COMMUNITY SERVICES DEPARTMENT

Subject: Sterling Ranch Sketch Plan Amendment (SKP-18-003)

The Planning Division of the Community Services Department has reviewed the Sterling Ranch Sketch Plan Amendment, and has the following comments of behalf of El Paso County Parks. This application will be presented to the Park Advisory Board September 12, 2018.

STERLING RANCH SKETCH PLAN AMENDMENT

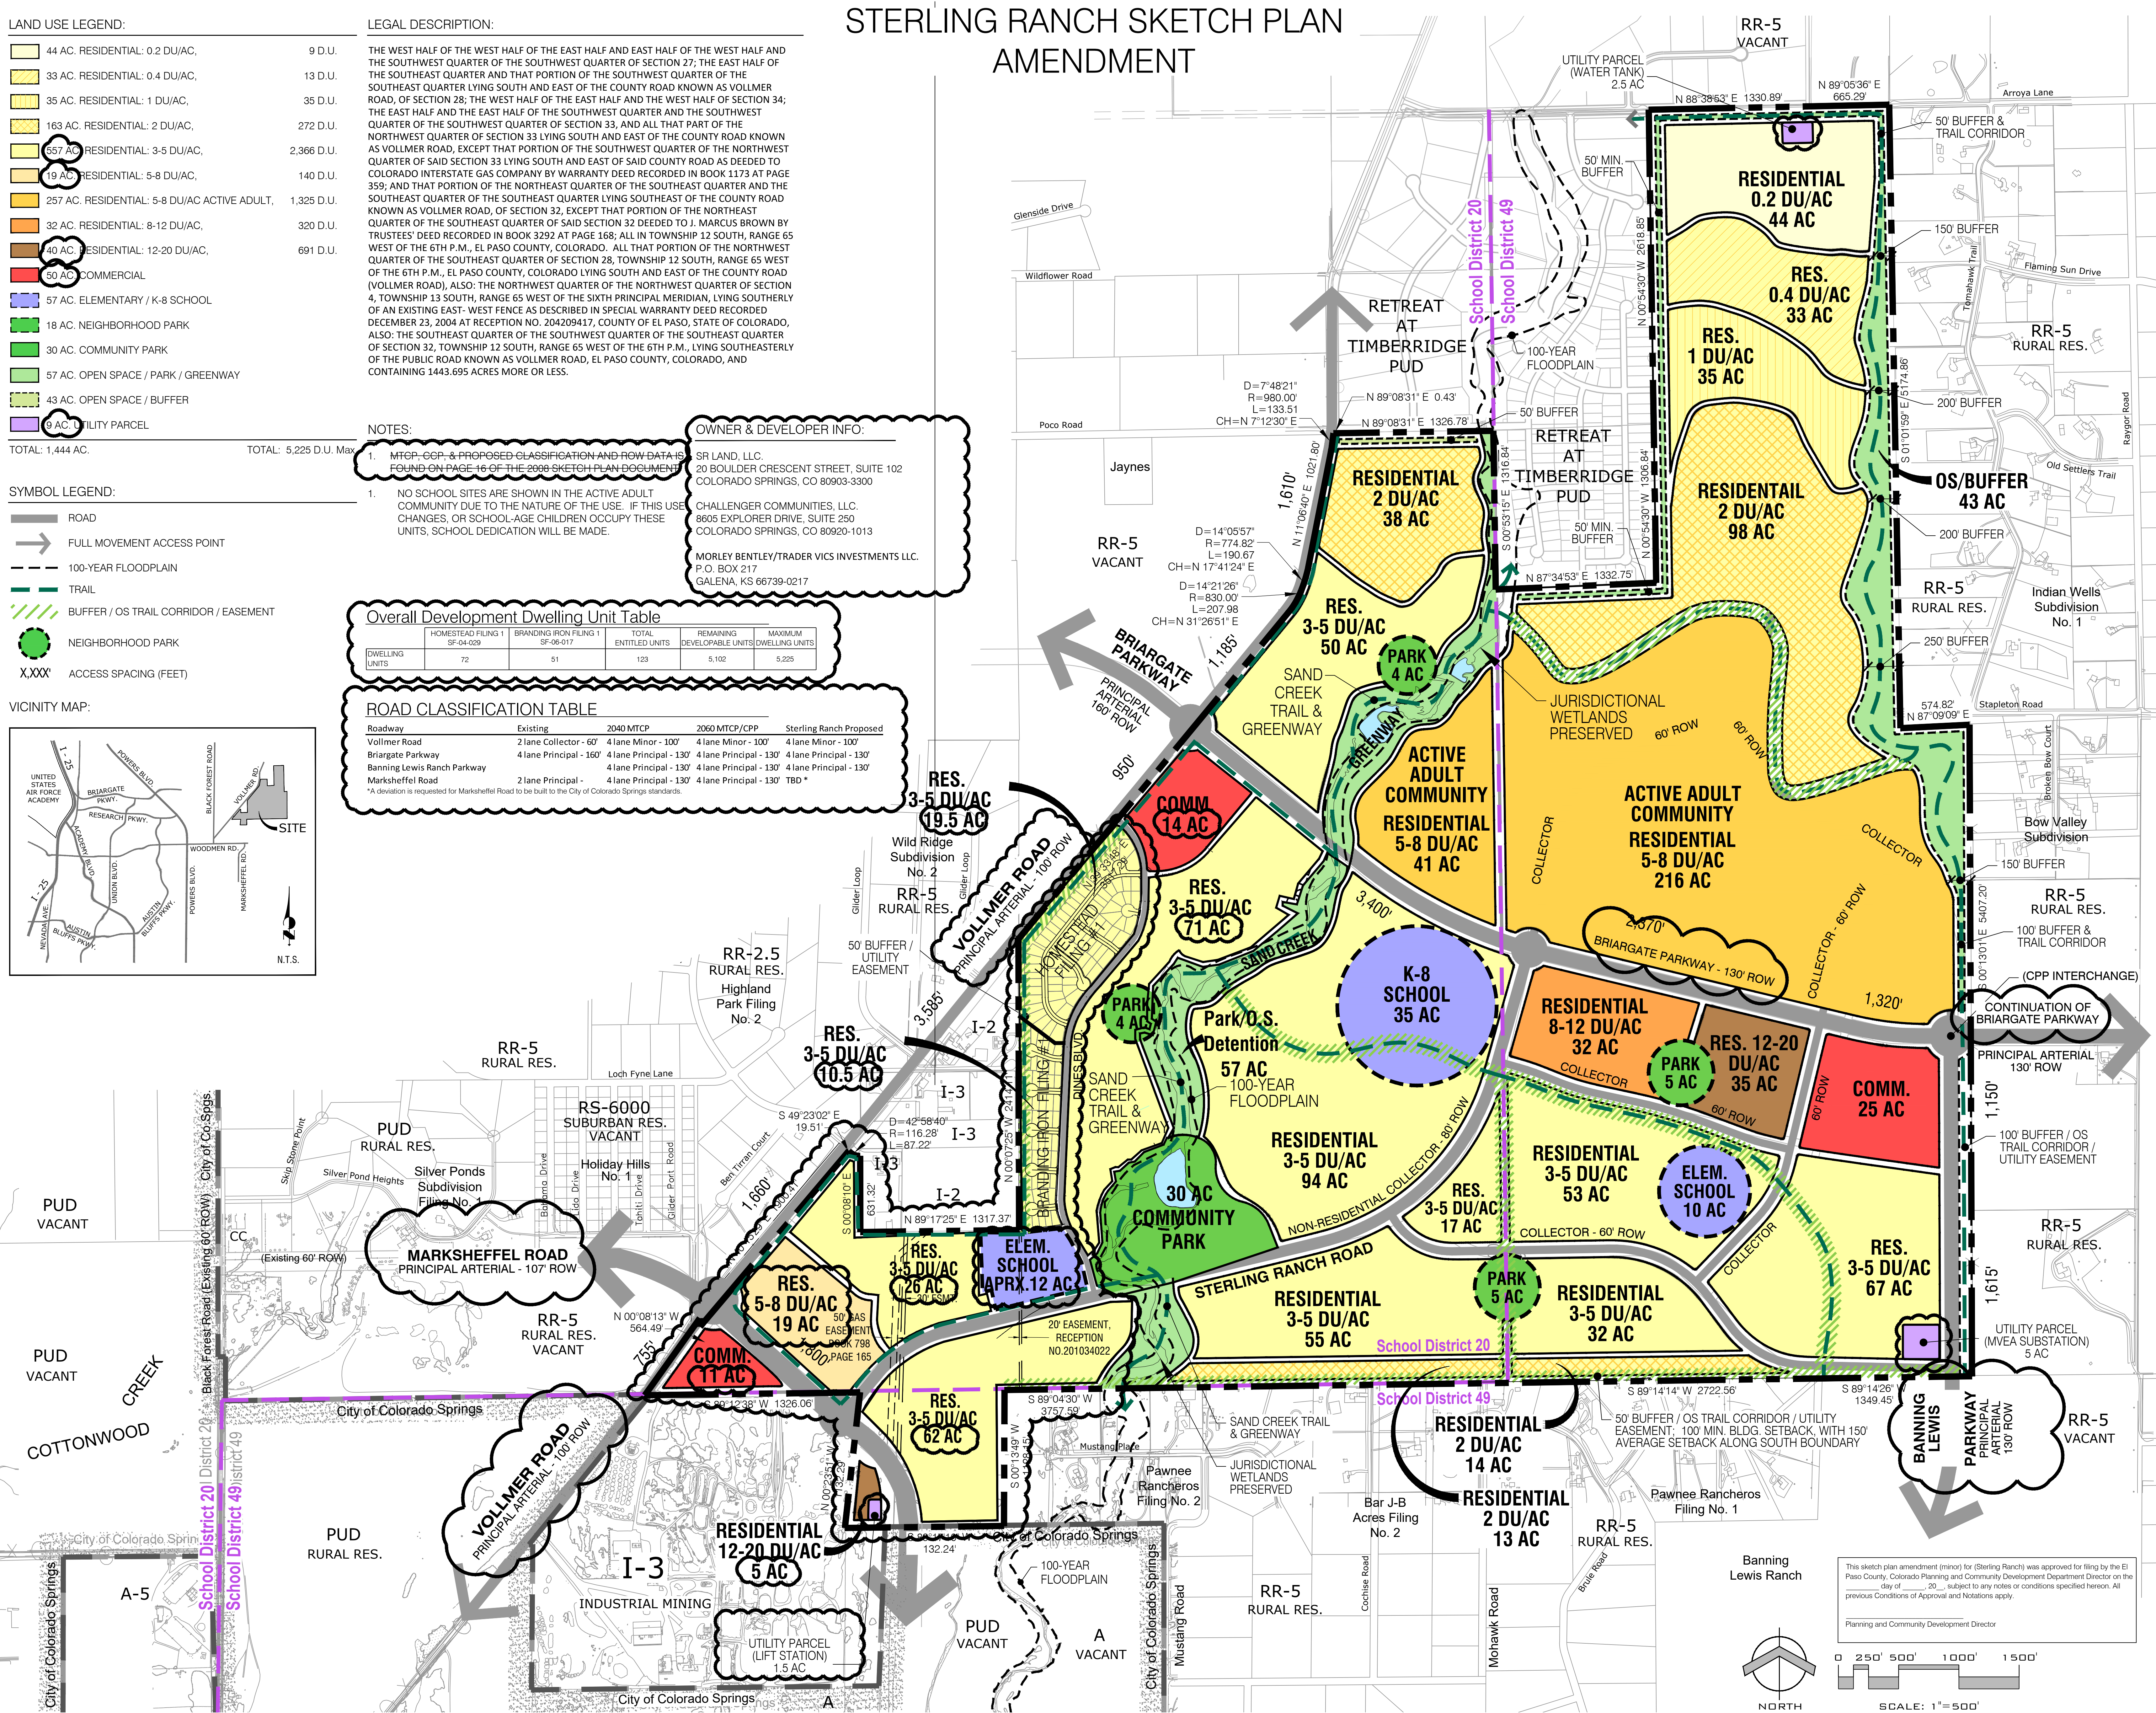
Staff recommends that the developers designate and provide to El Paso County 25-foot trail easements along the remaining sections of Sand Creek, as well as along the southern side of Arroyo Lane for the purpose of construction and maintenance of the Sand Creek Regional Trail and the Arroyo Lane Regional Trail, respectively. Staff also encourages the developers to construct the aforementioned proposed neighborhood and community parks, so as to provide recreational opportunities for residents and visitors of Sterling Ranch. Furthermore, staff encourages the developers to construct internal trail systems that link residents not only to the proposed neighborhood and community parks, but also to the County's regional trail system.

Recommend to the Planning Commission and the Board of County Commissioners that the approval of Sterling Ranch Sketch Plan Amendment includes the following conditions: (1) designate and provide to El Paso County a 25-foot trail easement along the Sand Creek corridor, that allows for public access, as well as construction and maintenance by El Paso County of the Sand Creek Regional Trail, (2) designate and provide to El Paso County a 25-foot trail easement along south side of Arroyo Lane, that allows for public access, as well as construction and maintenance by El Paso County of the Arroyo Lane Regional Trail, (3) the easements shall be shown on all forthcoming preliminary plans and final plats, and the aforementioned easements shall be dedicated to El Paso County on the forthcoming final plat(s), (4) fees in lieu of land dedication for regional and urban park purposes will be calculated upon review of forthcoming preliminary plans and final plats, and will be required at time of the recording of the forthcoming final plats.
